[REDACTED] **ADC Drainage Engineers objecting to Conditions 3 and 5 of**
BN/127/21/DOC.

Subject: RE: Planning Consultation on: BN/127/21/DOC

Application No: BN/127/21/DOC
Registered: 27th September 2021
Site Address: Land At Angels Nursery Yapton Road Barnham PO22 0AY
Description of Works: Approval of details reserved by condition imposed under BE/84/20/PL relating to conditions 3-as built drawings of implemented SuDS scheme & 5-updated copy of management manual or confirmation that no changes are required to manual.

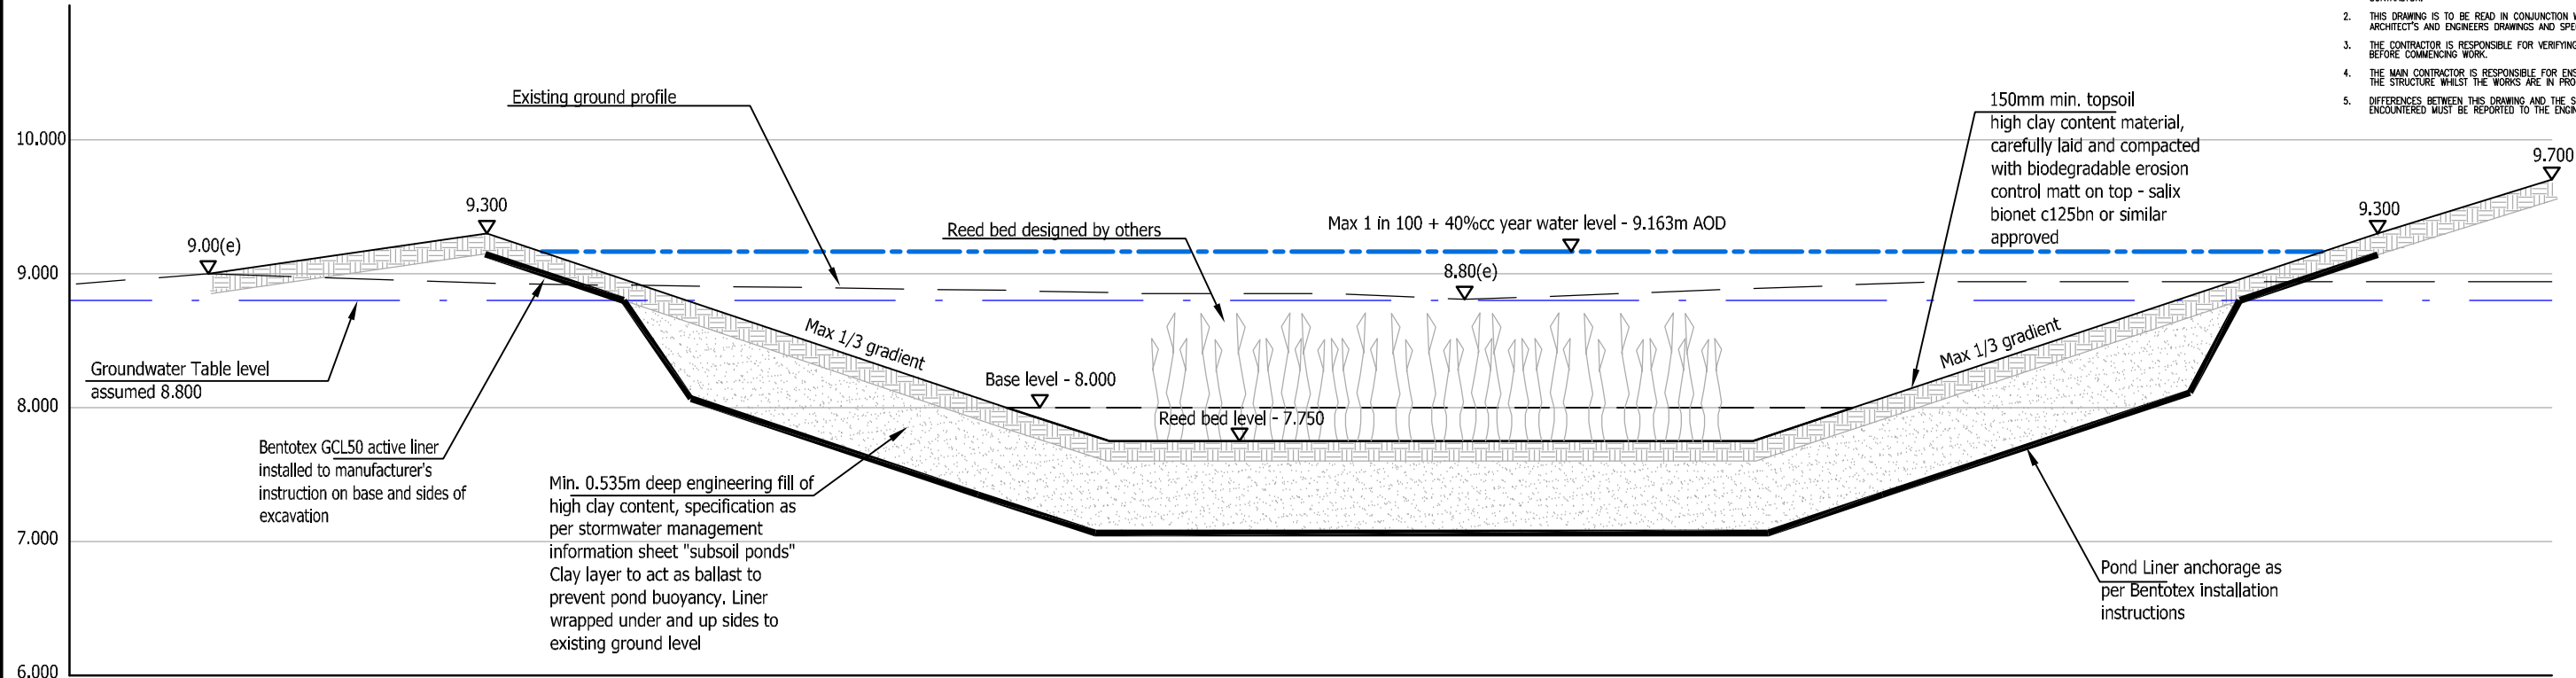
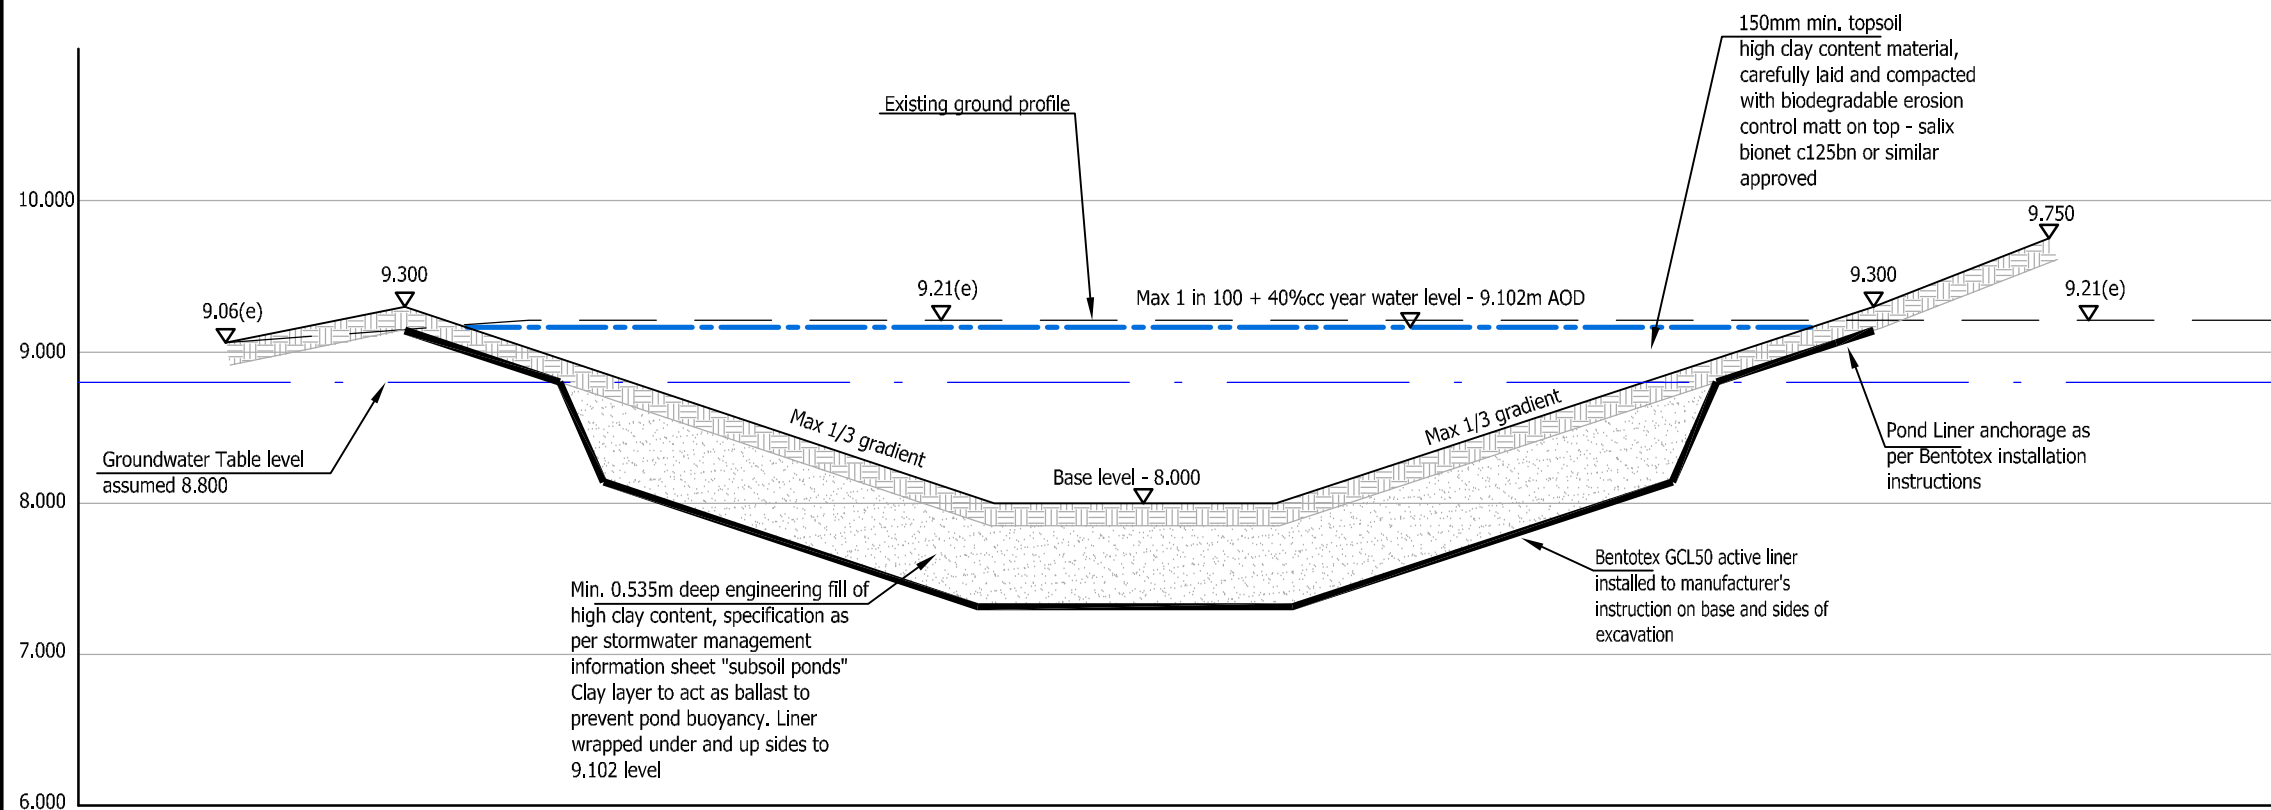
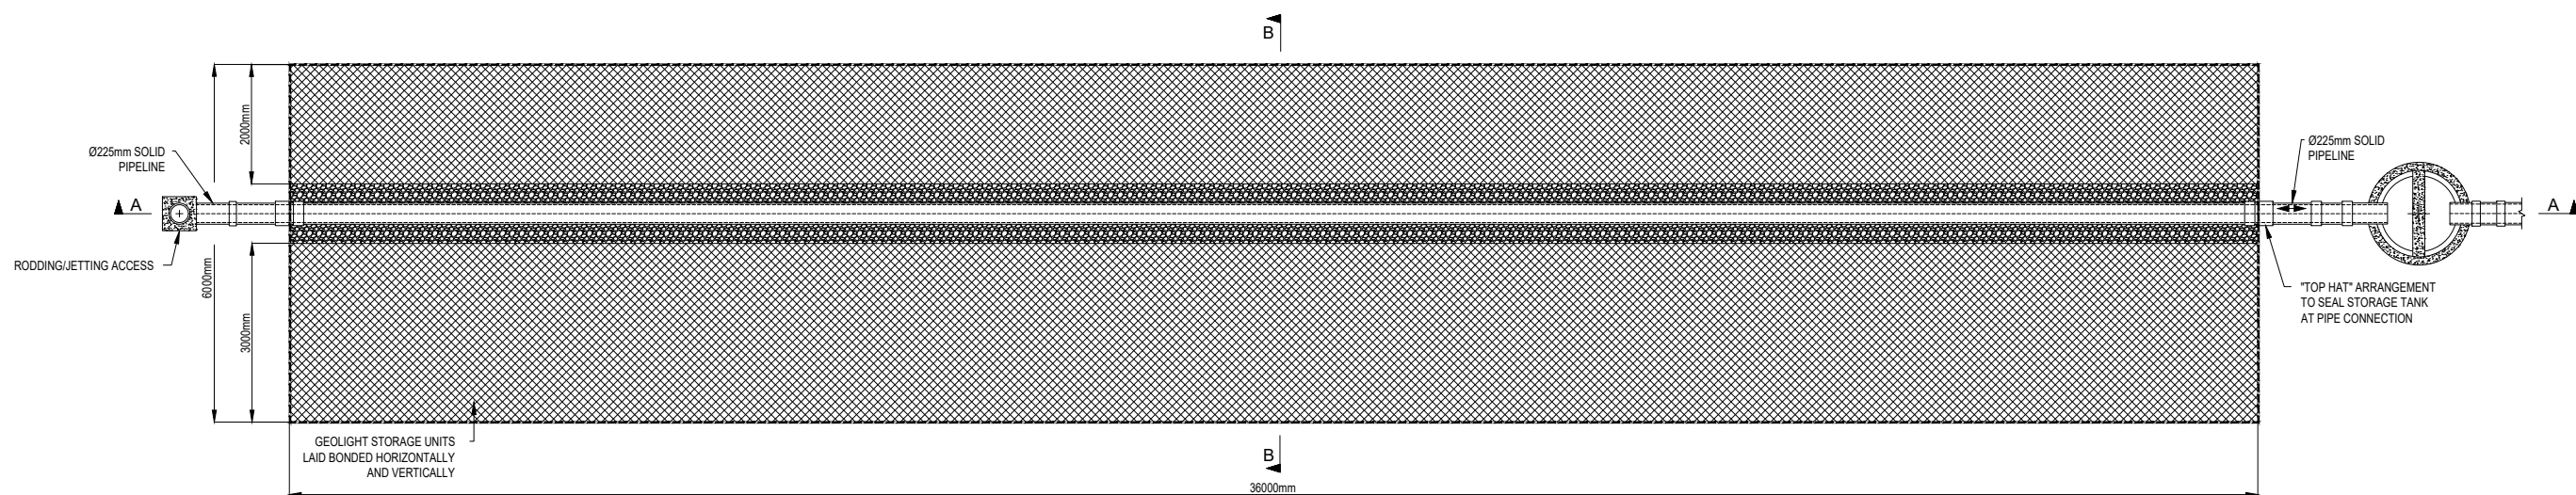
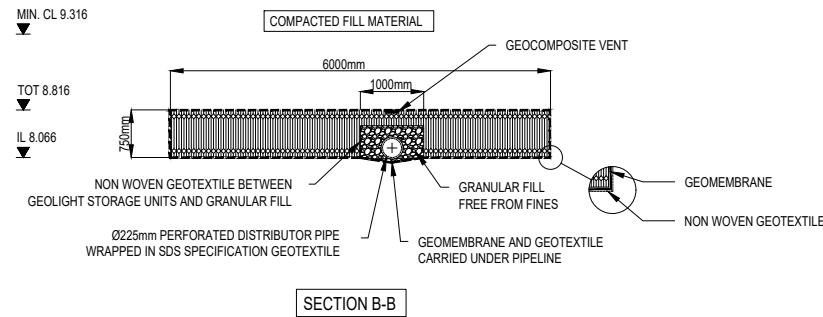
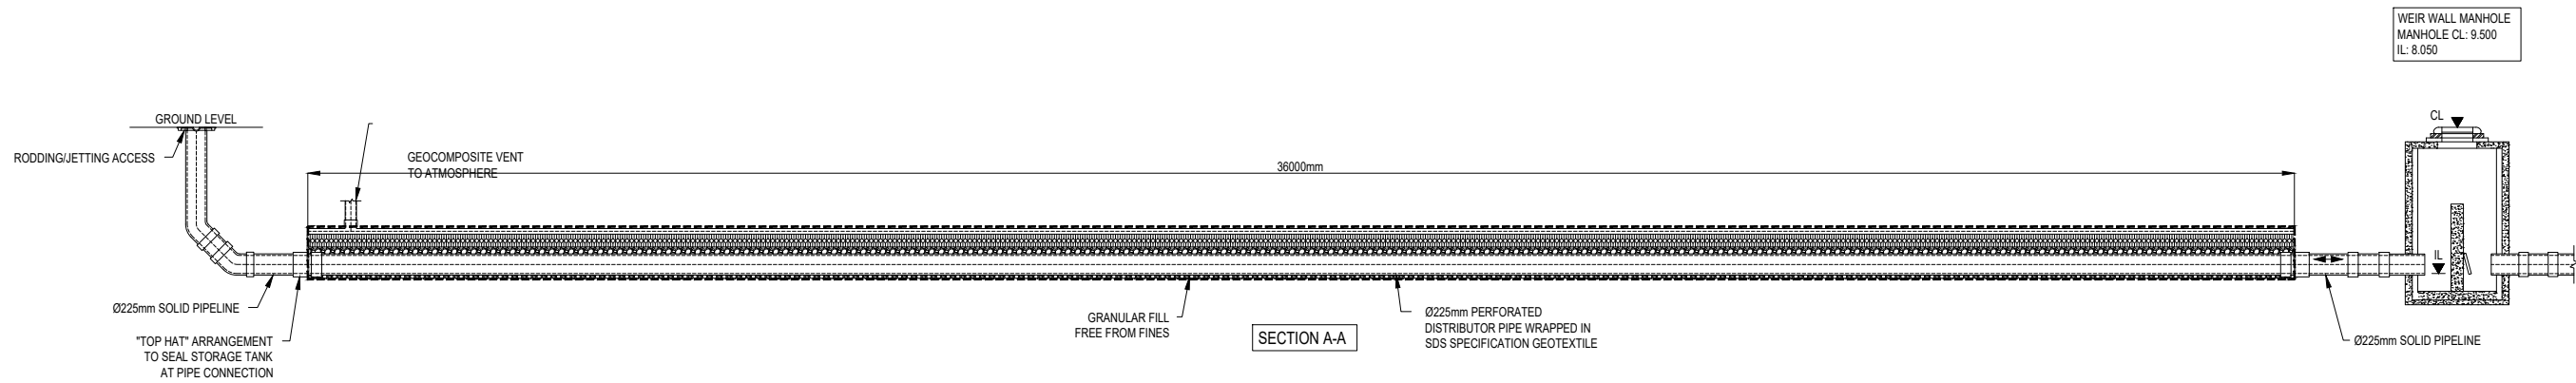
1. Please can the author of the verification report detail their independence and qualifications. *Ok. Okay.*
2. Please can the author of the verification report provide a clear statement regarding their view on the adequacy of the constructed surface water drainage. It is clear that the SuDs is adequate. A sentence will be added to the document, however it does confirm that SuDs have been constructed in accordance with the construction drawings. *The report is limited to a review of the attenuation features only, this does not meet the requirements of this condition. We expect to see details of the entire network, permeable paving, attenuation features, flow control devices, outfalls, etc. We also note that photos 13 and 14 appear to show pins perforating the impermeable membrane to the tank, it is unclear how the membrane is deemed to be watertight.*

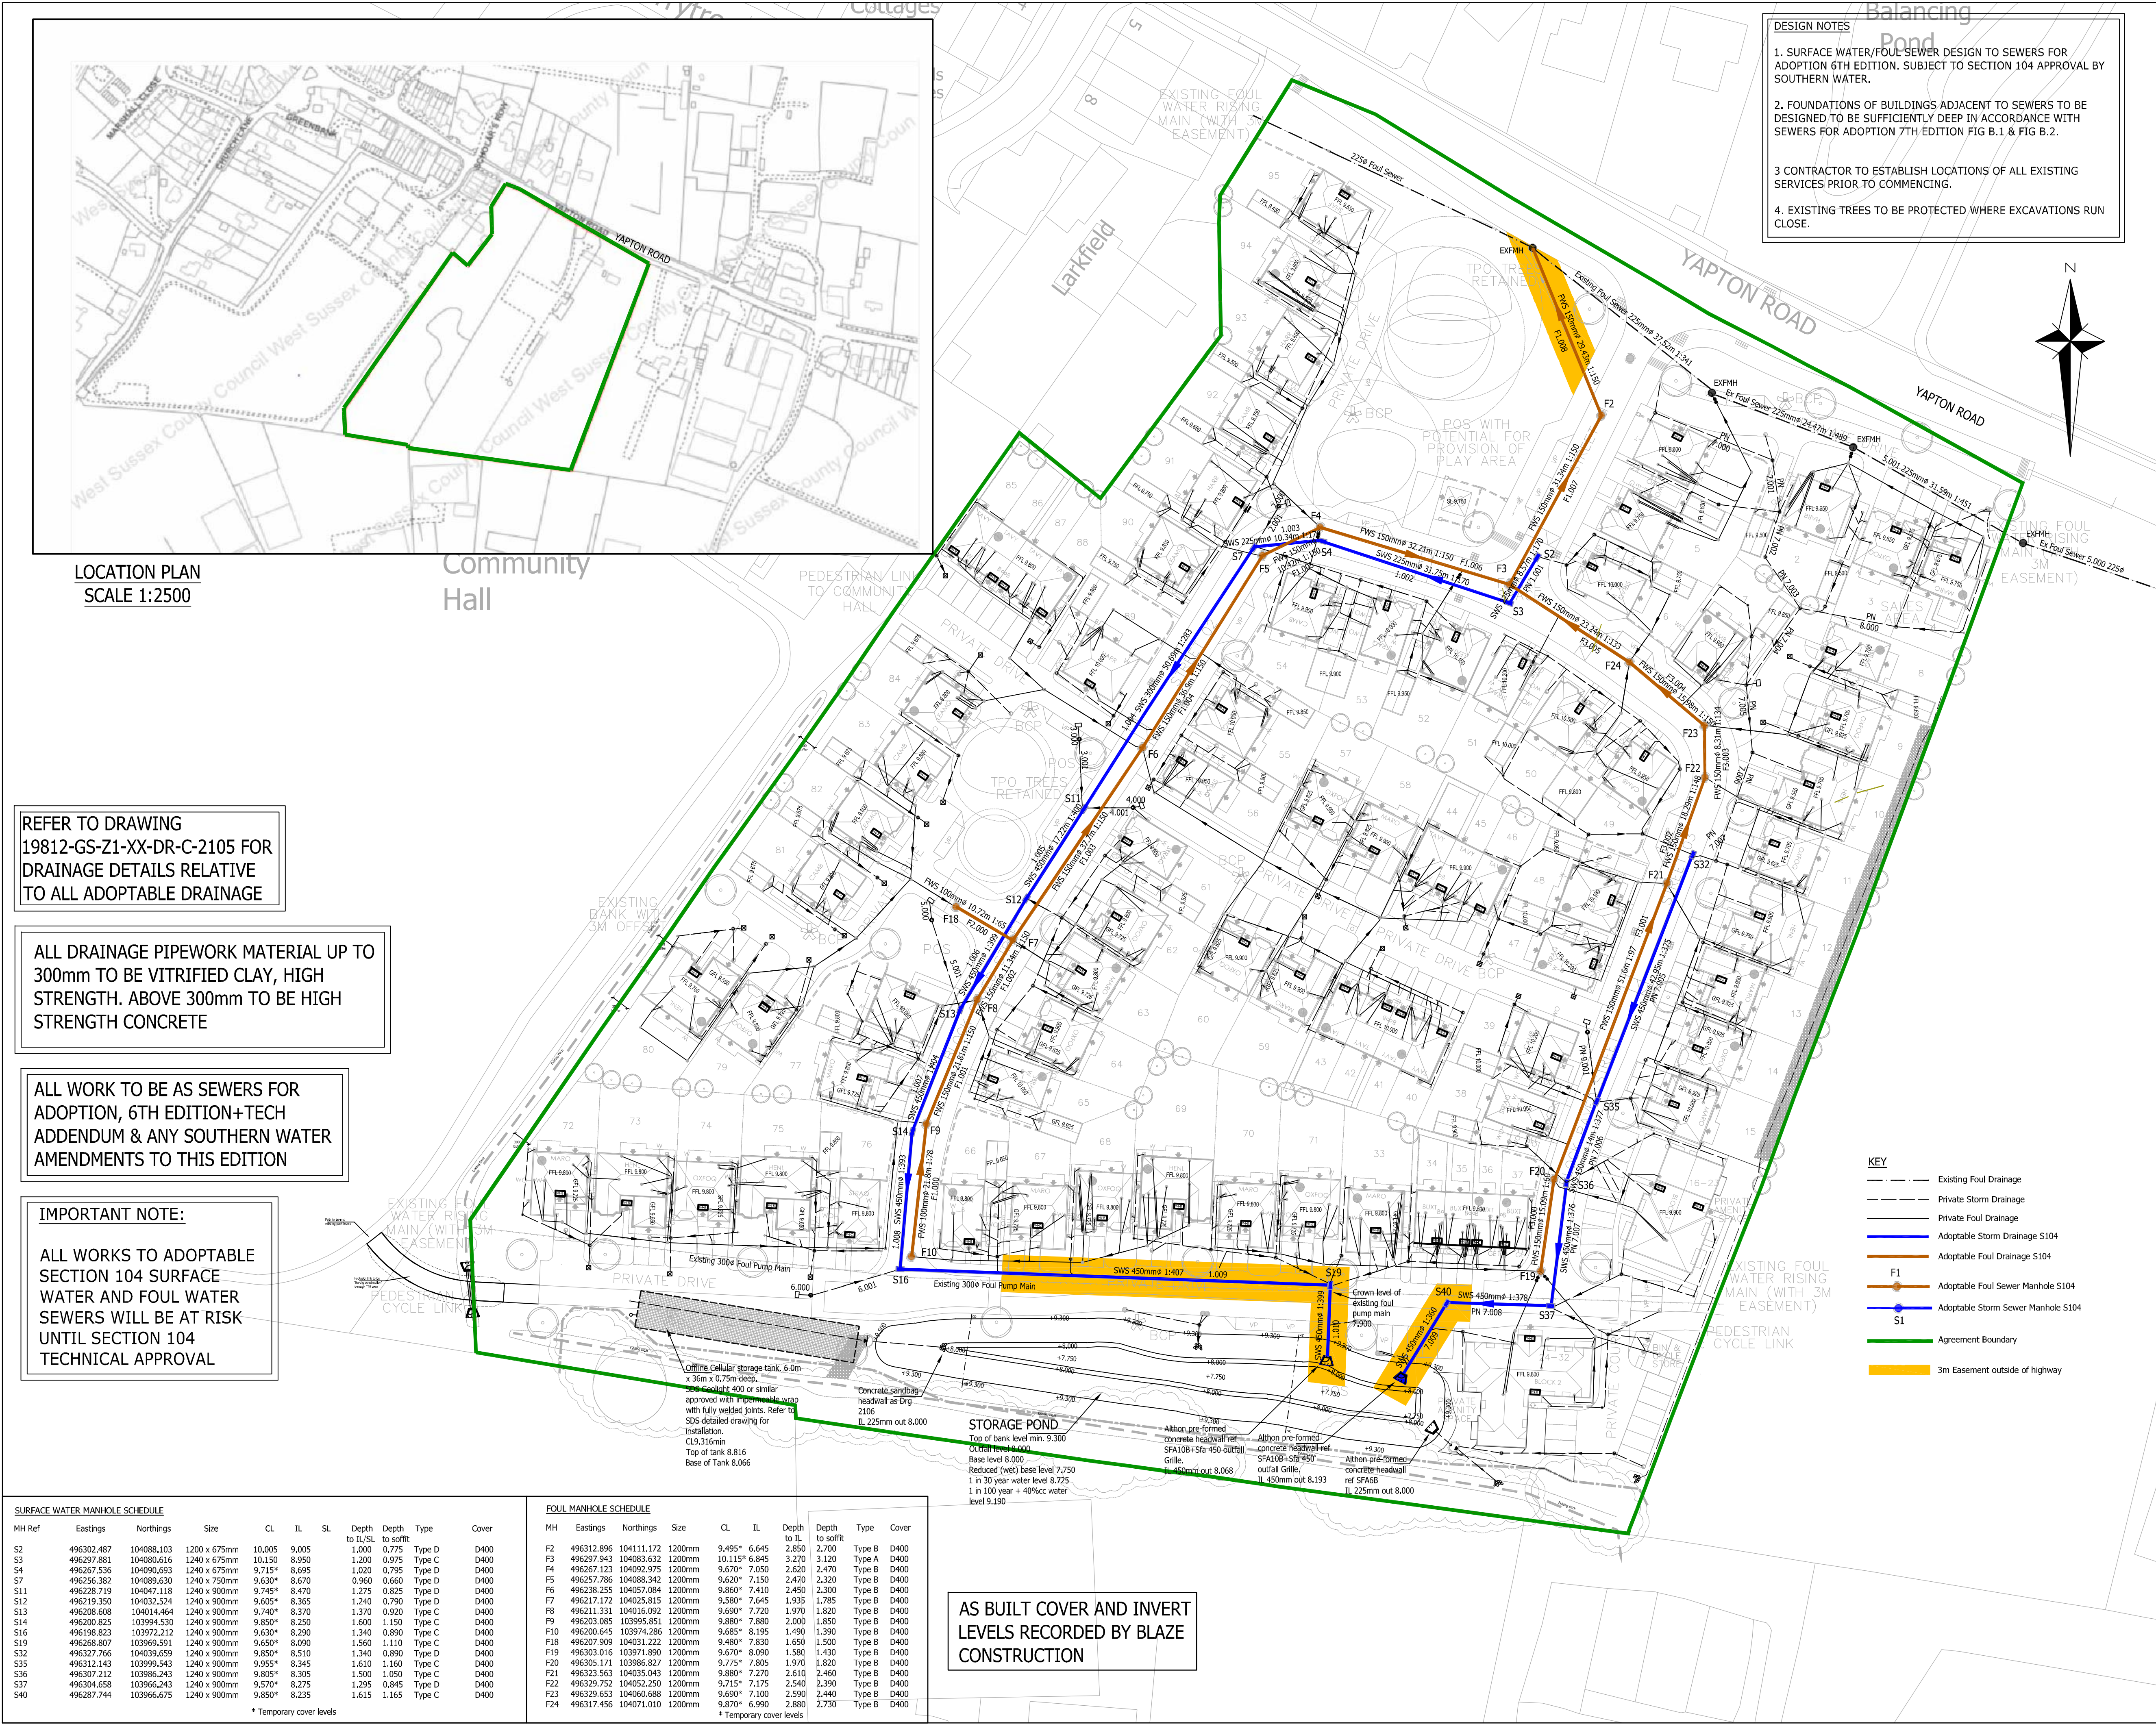
3. Please provide fully detailed as built layouts. As built survey should extend to the permeable paving, full pipe network, and include attenuation features, flow control device and outfall.

4. The report should comment upon any discrepancies between as built survey and design. The report confirms that accordance with the construction drawings. *The report is limited to a review of the attenuation features only, this does not meet the requirements of this condition. We expect to see details of the entire network, permeable paving, attenuation features, flow control devices, outfalls, etc. We have spot checked some of the as built levels and there are small discrepancies to design. Differences to design should be tabulated and comments regarding potential impact should be provided.*

The updated as built layout, which excludes the work that Redrow are not able to carry out on land outside of our ownership will follow on shortly.
